# HAVEN FOREST SCHOOL

# CONSTRUCTION DRAWINGS

**PCD FILE NO. PPR-2423**

**BURGESS ROAD**  
**PLAN & PROFILE**  
(STA: 11+00 TO STA: 22+90)

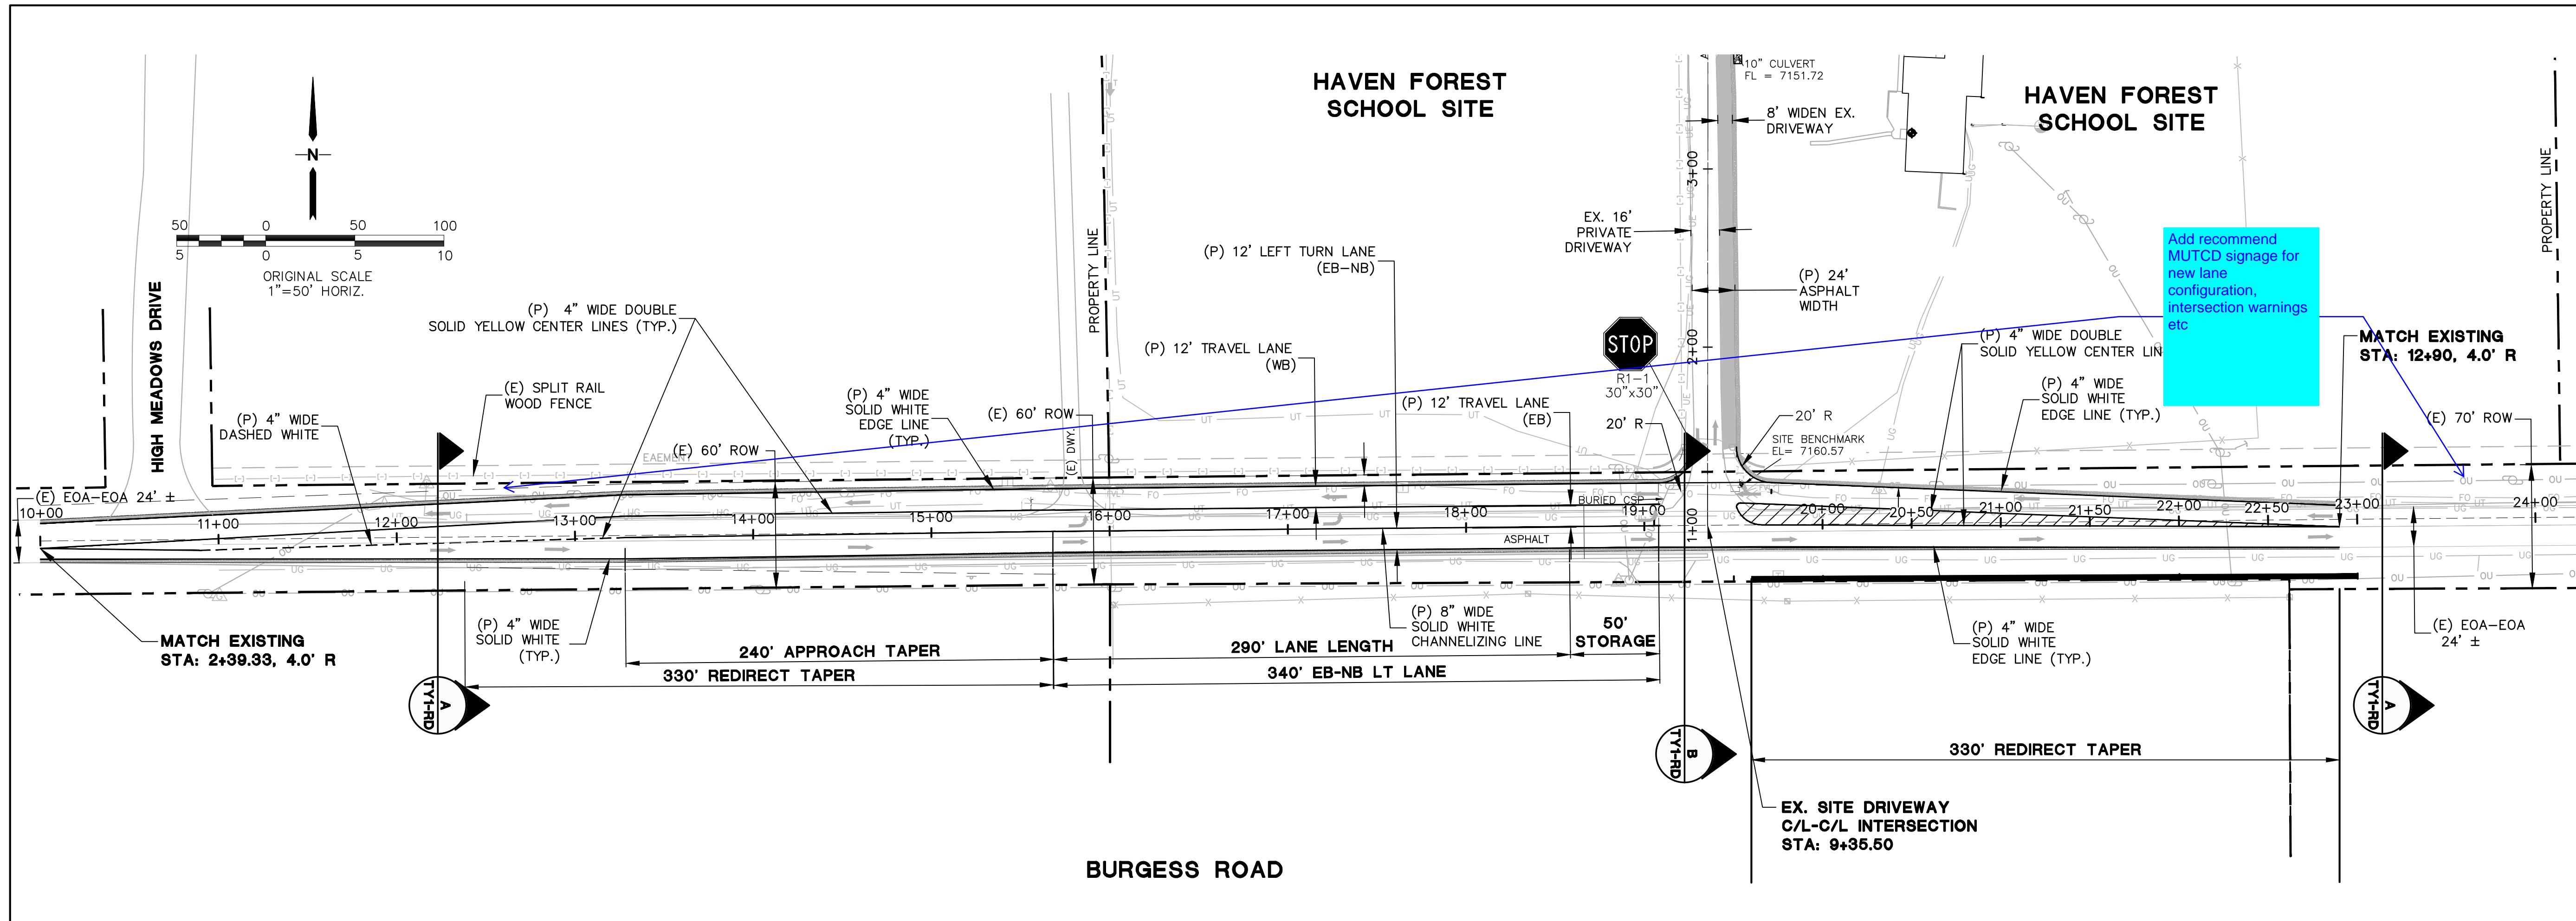
This does not appear to provide proper EB through lane width. Please show lane widths at beginning and end of all tapers.

This shows approach taper and redirect taper overlapping, which is incorrect. However, previous sheet shows it correctly. Change this sheet to match the previous sheet.

Add LT Pavement Arrows (Thermoplastic) at beginning and end of LT lane

Hatching should be go the other direction. Hatches need to lead traffic back to the correct direction. Also need to call out the hatching.

Burgess Road posted speed: 45 mph  
 Burgess Road classification: Minor Arterial  
 Burgess Road design speed: 60 mph per ECM; 50 mph per posted + 5  
 Turn Lane Length: 290 ft  
 Approach Taper Length: 240-ft  
 Approach Grade: 7.5% upgrade; Grade Adjustment Factor is 0.80;  
 Approach taper can be reduced by 20% or to 192-ft  
 Through Lane Redirect Taper: 55:1
